**DECISION DELEGATED TO HEAD OF PLANNING**

**Application No:** H07-1204-25                      **Applicant:** Mr & Mrs Young  
**Proposal:** Extension & Alterations to Dwelling & Erection of Garden Shed  
**Location:** 3 Sycamore View Gedney Hill Spalding  
**Terminal Date:** 20th February 2026

SOUTH WEST ELEVATION 1:100

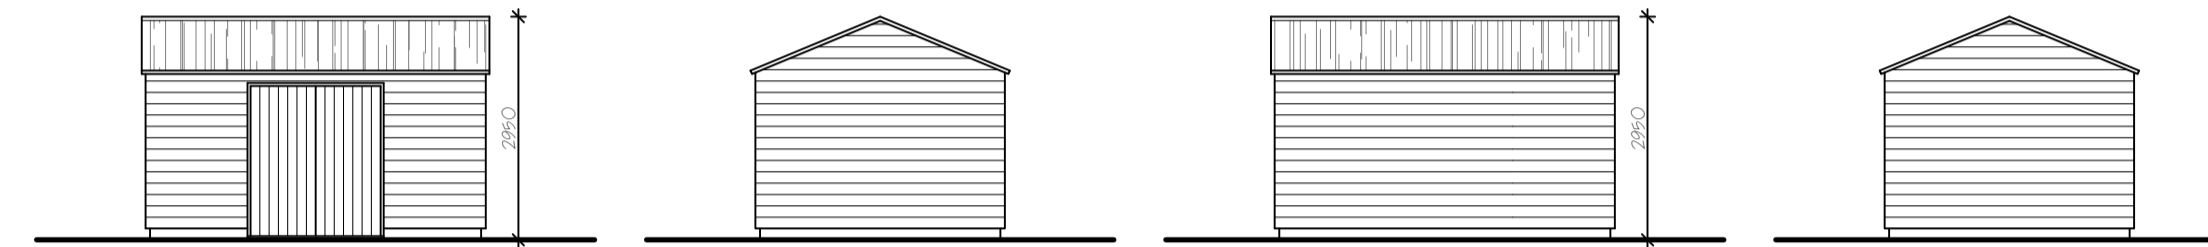
In regard to overlooking, there would be three windows and one door on the ground floor and one window and a Juliet balcony on the first floor. Firstly, the ground floor windows and door would cause no material harm through overlooking due to there proposed siting to the ground floor. This siting, coupled with existing boundary treatments, limit any potential harm.

The first floor windows would be sited within the new master bedroom and would face south and north west respectively. The window on the front elevation (south) would only face Sycamore View itself and would provide no new views in comparison to that which it currently affords from the front elevation windows. As such, no significant or unacceptable increase in overlooking would be proposed as a result of this.

Whilst the Juliet balcony would be a new addition on this elevation and thus would provide a new view, it is not considered to give rise to a significant or unacceptable adverse or harmful impact. It is noted that this addition could provide some views into No. 5 Sycamore View, particularly its garden area; however, it was noted during the officers visit that this dwelling itself has windows which look directly into the rear garden of No. 3 and the level of outlook would not be significantly different, demonstrating that this is not an uncommon feature. Finally, it would be set around 18m from the boundary of No. 6 Station Road, this is considered to be an acceptable distance so that they would not materially impacted either.

GARDEN SHED ELEVATIONS-PROPOSED 1:100

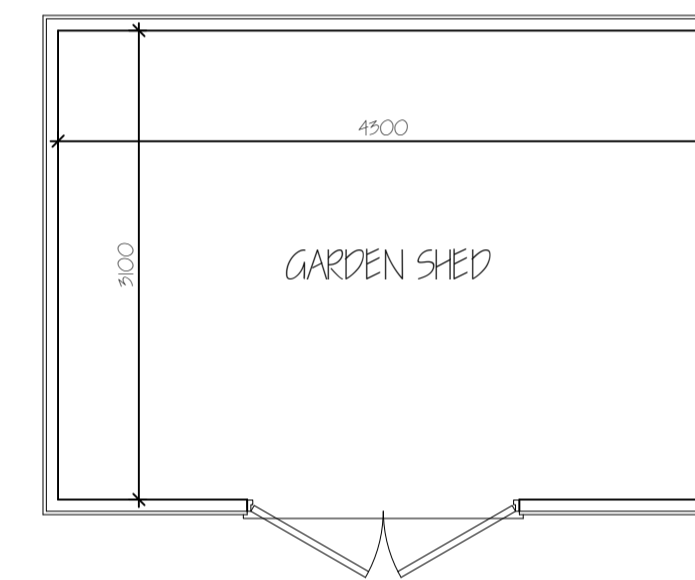
The garden shed would be constructed from timber feather board tiles to match the existing timber doors. It would have a total height of 2950mm and would have an internal floor space of just over 13sqm.

The garden shed is constructed from relatively standard materials and is of a typical design to what would be expected for residential sheds such as this. The materials are therefore considered to be acceptable. The design in terms of scale and size is also considered to be fairly standard and would not harm the area either. Due to its location it would not be visible from the highway in any capacity and is thus concealed from view.

The garden shed should also not cause any material harm through overshadowing or overlooking due to its location which is set away from any nearby residential dwellings. The same reasoning can be applied through overshadowing with the positioning benefitting this part of the scheme. It is also much lower than the main house, which itself causes no material harm through overshadowing. No windows are proposed across any elevations with it also not being classed as a habitable room either so no material overlooking could occur.

FIRST FLOOR PLAN 1:50

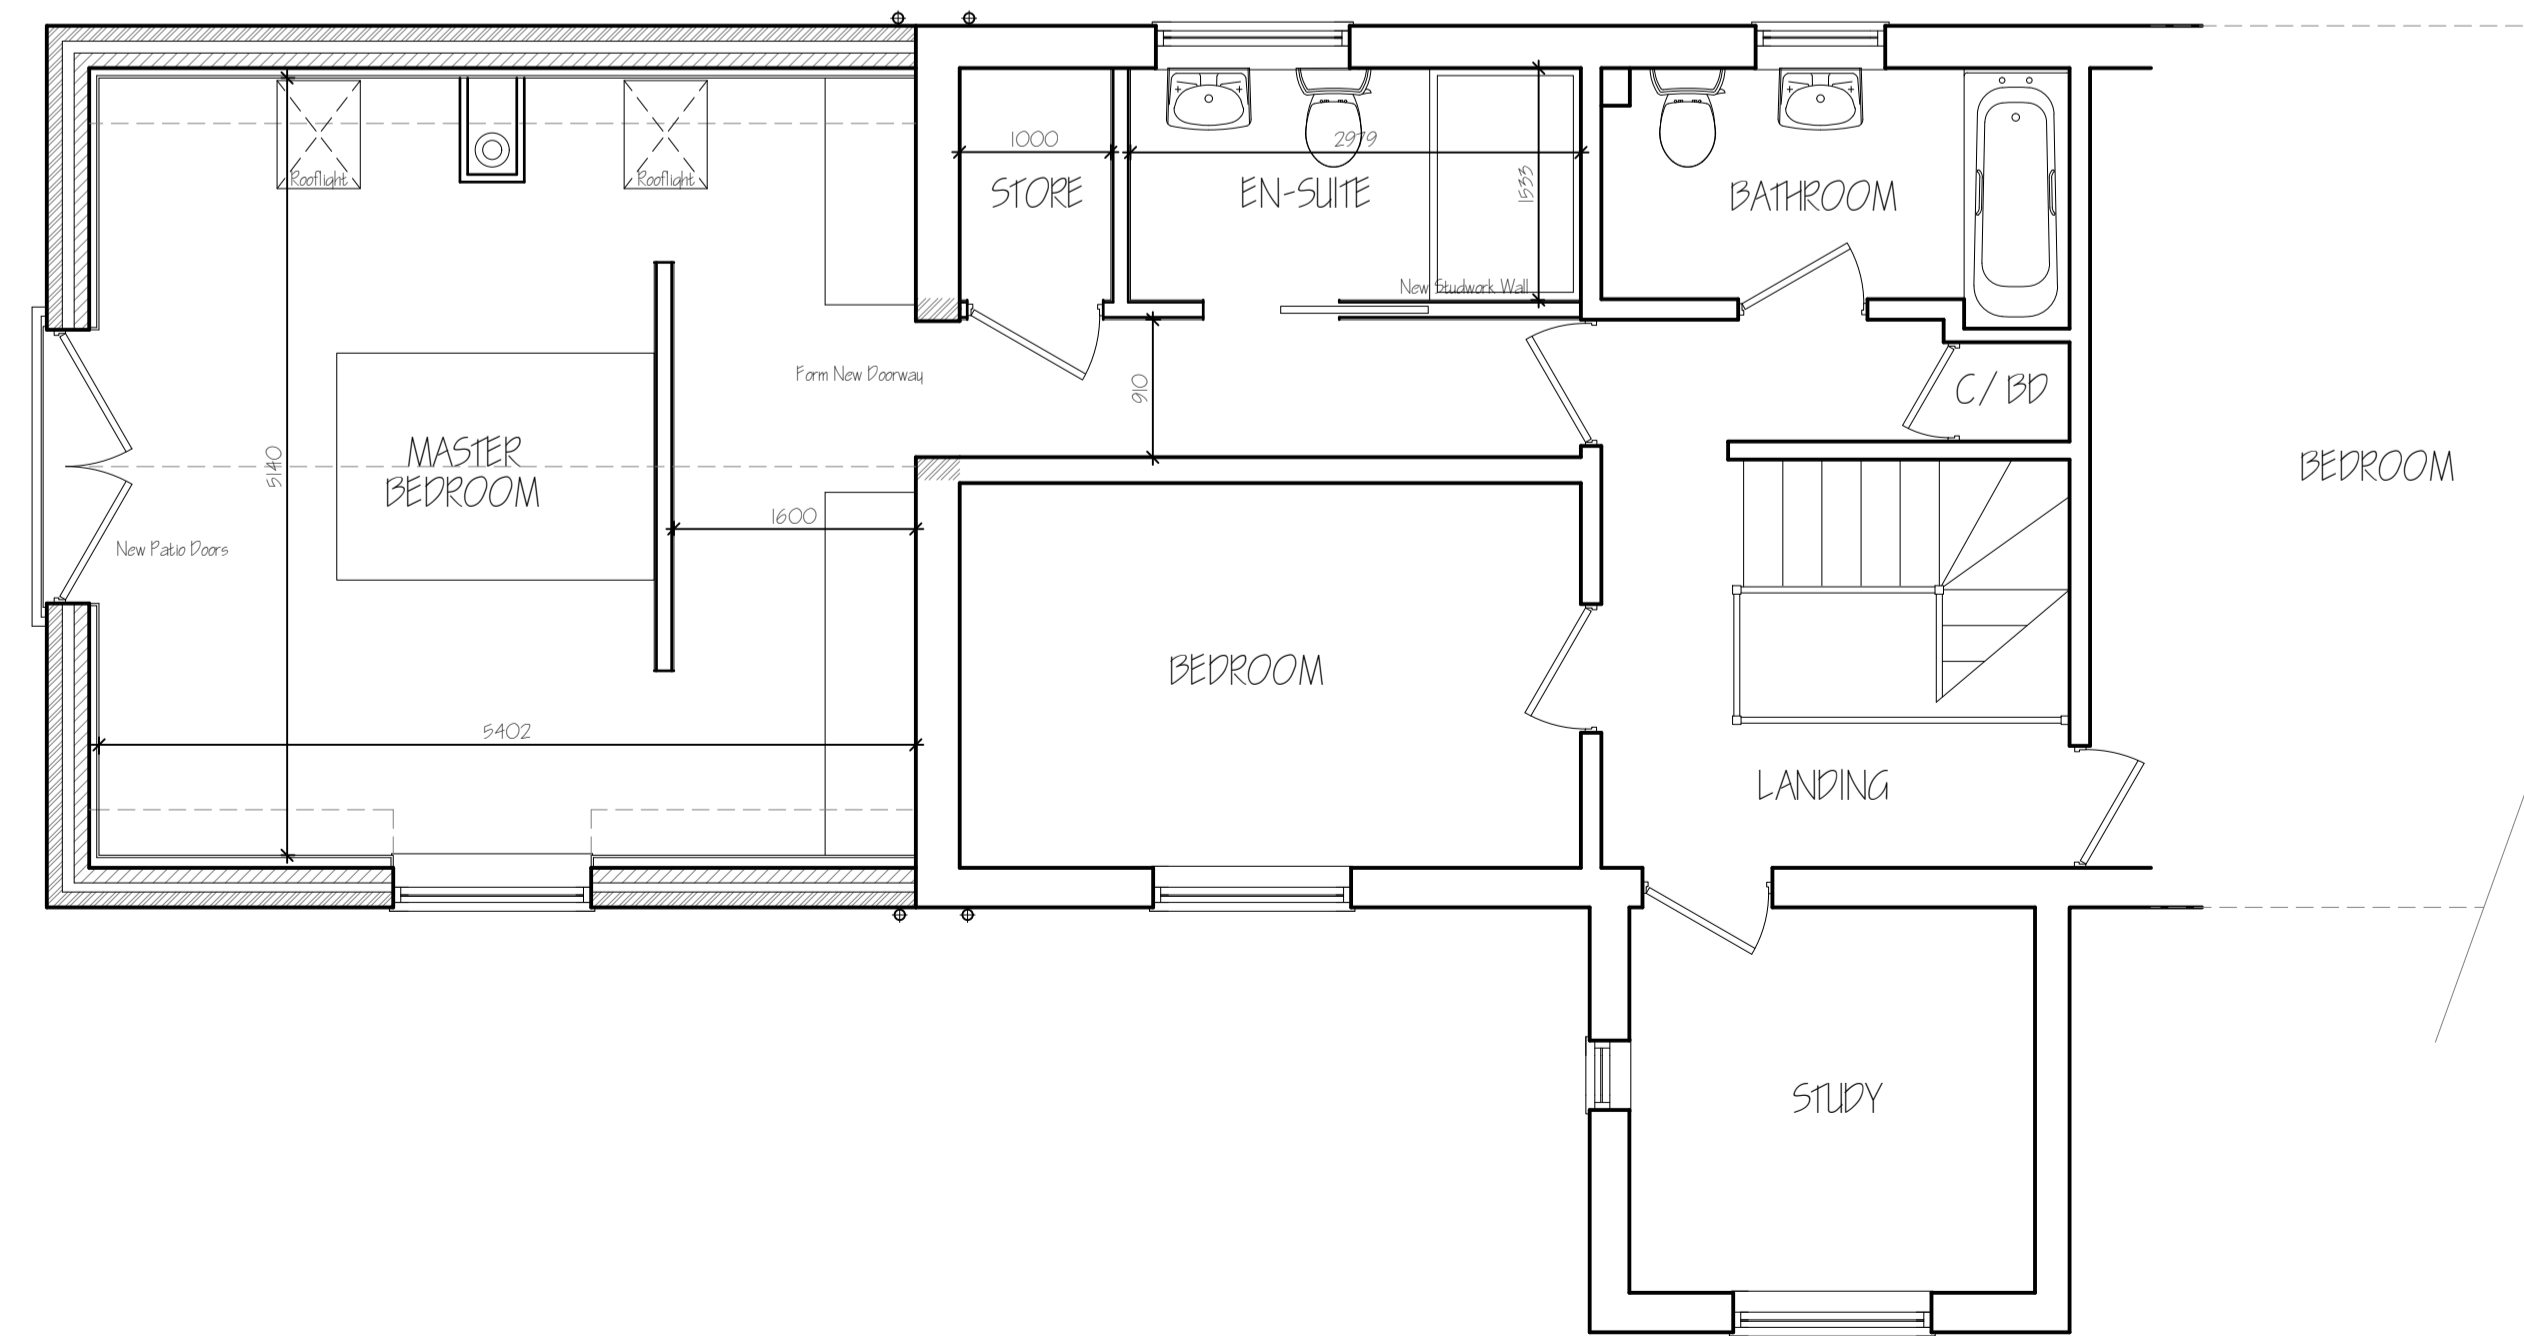
The proposed extension would comprise an additional first floor above a current garage, and would protrude from the side elevation by approximately 5700mm and would have a width of 5800mm. The height would sit lower than the eaves and ridge of the main house and therefore make the extension appear subservient. It would also be constructed from materials to match the host dwelling throughout.

The extension would protrude from the first floor side elevation by approximately 5700mm and would have a width of 5800mm. This would ensure that it would sit on the same footprint as the existing ground floor garage so that it does not appear disproportionate in relation to the rest of the dwelling. Whilst no other dwellings on this estate have constructed an extension above their representative garage, the extension is of a fairly modest scale and would not cause harm to the area.

Alongside this, the height of the proposed extension would be set as to be below that of the main dwelling and therefore ensures that the proposal would appear subservient and subordinate. The height, combined with the size and scale of the extension, proposes a proportionate and thus acceptable extension and one that would not harm the street scene.
